To the NSW Department of Planning & Infrastructure

This submission is in response to the CSELR EIS currently on exhibition.

This submission is on behalf of the residents of Alison Road (and neighboring streets) who have formed a group, Need Alison Road Parking (NAP)

Figure 1A

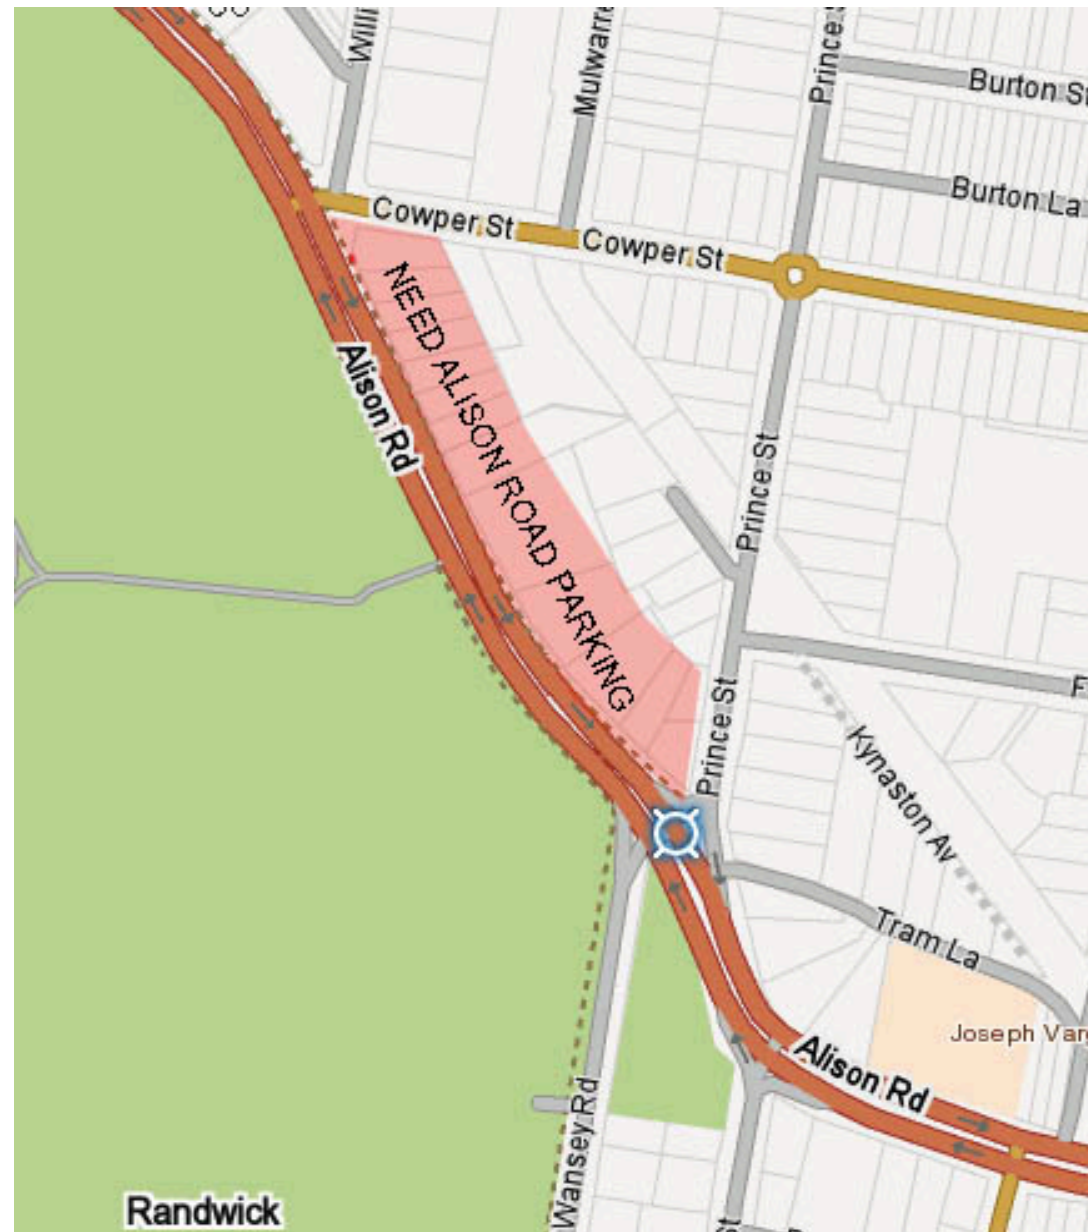
- NAP - Need Alison Road Parking
- This stretch of Alison Road is from Cowper Street on the western side to Prince Street on the eastern side.
- Currently there are 84 car spaces on both the northern & southern sides of the street.
- According to the EIS these are 85-100% occupied at all times (the southern side is only intermittent in use due to morning and weekend restrictions)
- A lack of supply (through the removal of on-street parking) will create severe parking shortages for residents and no alternatives have been suggested.

Figure 1B

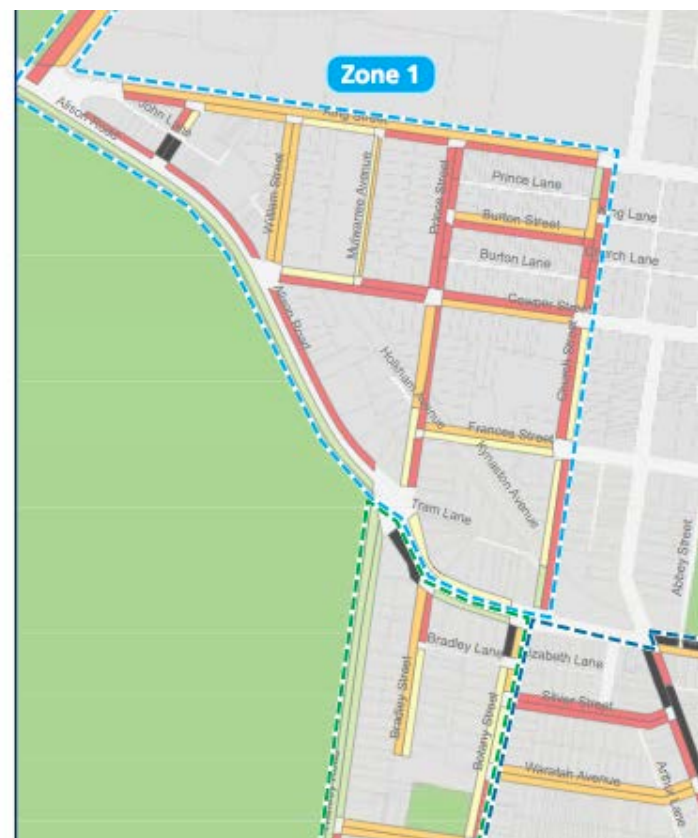
- Since the EIS was released, a residents parking scheme has been installed by Randwick Council on the northern side of Alison Road, validating the need for on-street parking for the residents of Alison Road between Prince & Cowper Streets.
- This has also changed the character of parking from 'short stay' high turnover parking to 'long stay' low turnover (residential) parking at peak and inter-peak times.

\* the figures below indicate in RED 85-100% occupancy of NAP stretch of Alison Road pre & post peak hour which indicates RESIDENT parking. During the rest of the day both sides of Alison Road (between Cowper & Prince St) are also highlighted in red.

Figure 5A

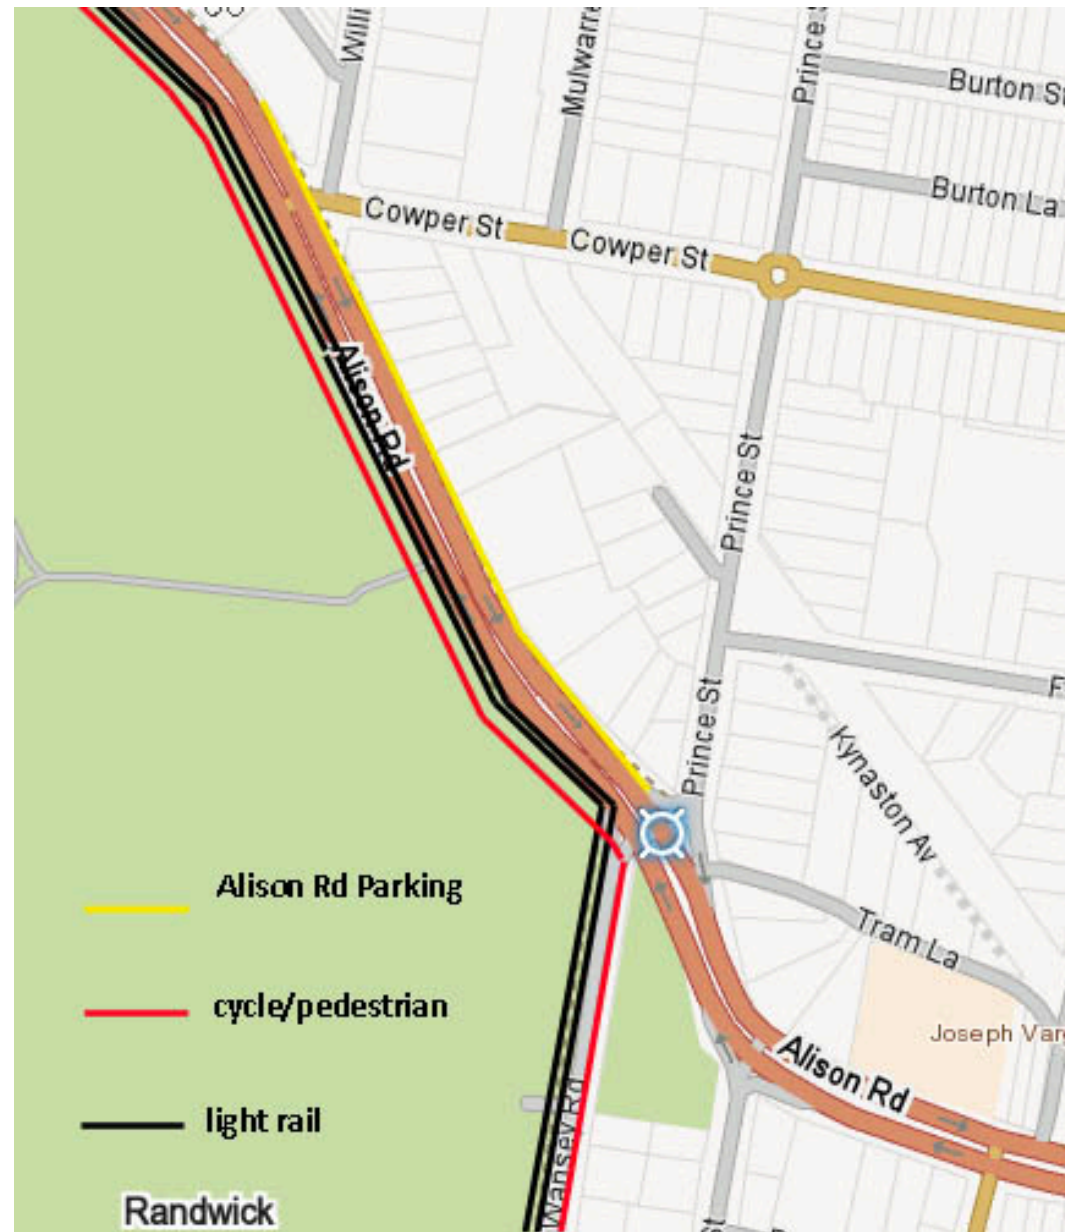
- The 3 lanes on the northern side of Alison Road remain as they are, ie. one residents parking lane and two traffic lanes travelling east.
- On the southern side the light rail will replace the pavement/cycle lane and take up the first lane of traffic, thereby leaving two lanes of traffic traveling west.
- The pedestrian lane/cycle lane will be relocated to the within the racecourse grounds where there already exists a substantial path which will suit both pedestrians and cyclists.
- This option is low impact as no major works would be required on the northern side of Alison Road.
- We also support the retention of the mature trees that line the Alison Road / racecourse boarder and would advocate for no overhead cables, in order to preserve the tree canopies.

- Retain the parking lane on the north side of Alison Road (yellow)
- Retain 2 lanes of traffic on the north side of Alison Road (orange)
- Retain 2 lanes of traffic on the southern side of Alison Road (orange)
- The light rail will take up 1 lane of traffic on the southern side and the pavement/cycle way (black)
- The pavement & cycle way will be relocated to the existing path within the racecourse grounds (red)
- Retain the mature trees that line the racecourse

Figure 7A

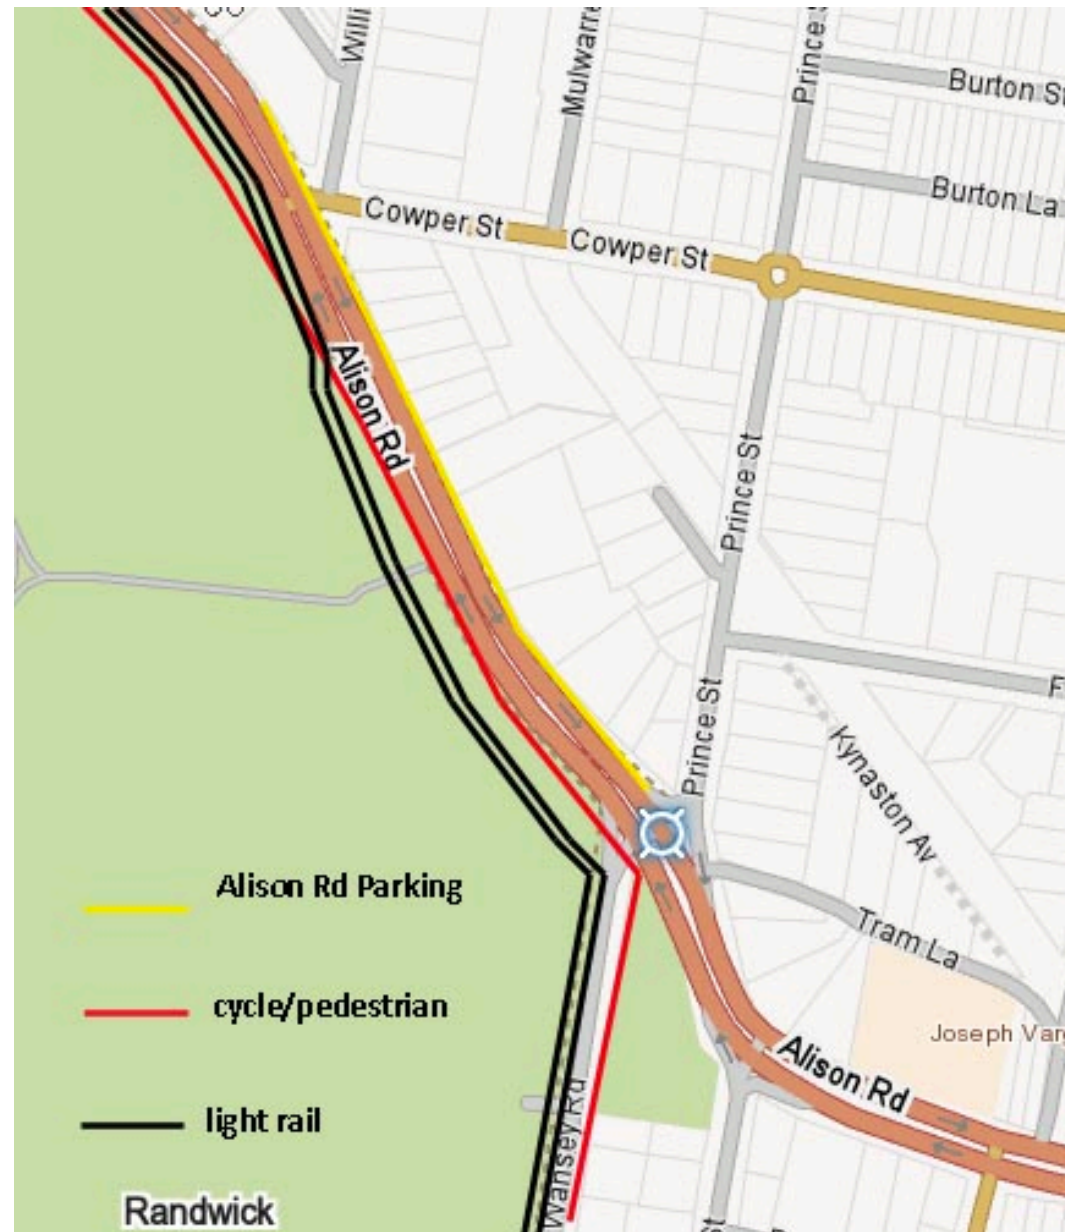
- Approximately 50m above the Cowper Street intersection, the light rail **moves into the periphery of the racecourse grounds**, up until the Wansey Road intersection.

- The northern side of Alison Road (before Wansey Rd) would retain it's parking lane and two lanes of east bound traffic. The southern side would retain the three lanes of west bound traffic, which affords intermittent parking for residents on the southern side.

- Retain the parking lane on the north side of Alison Road (yellow)
- Retain 2 lanes of traffic on the north side of Alison Road (orange)
- Retain 2 lanes of traffic on the southern side of Alison Road (orange)
- The light rail will move into the racecourse 30m above the Cowper St intersection.
- The pavement & cycle way will be retained between Cowper St & Wansey Rd.
- Mature trees will be saved.
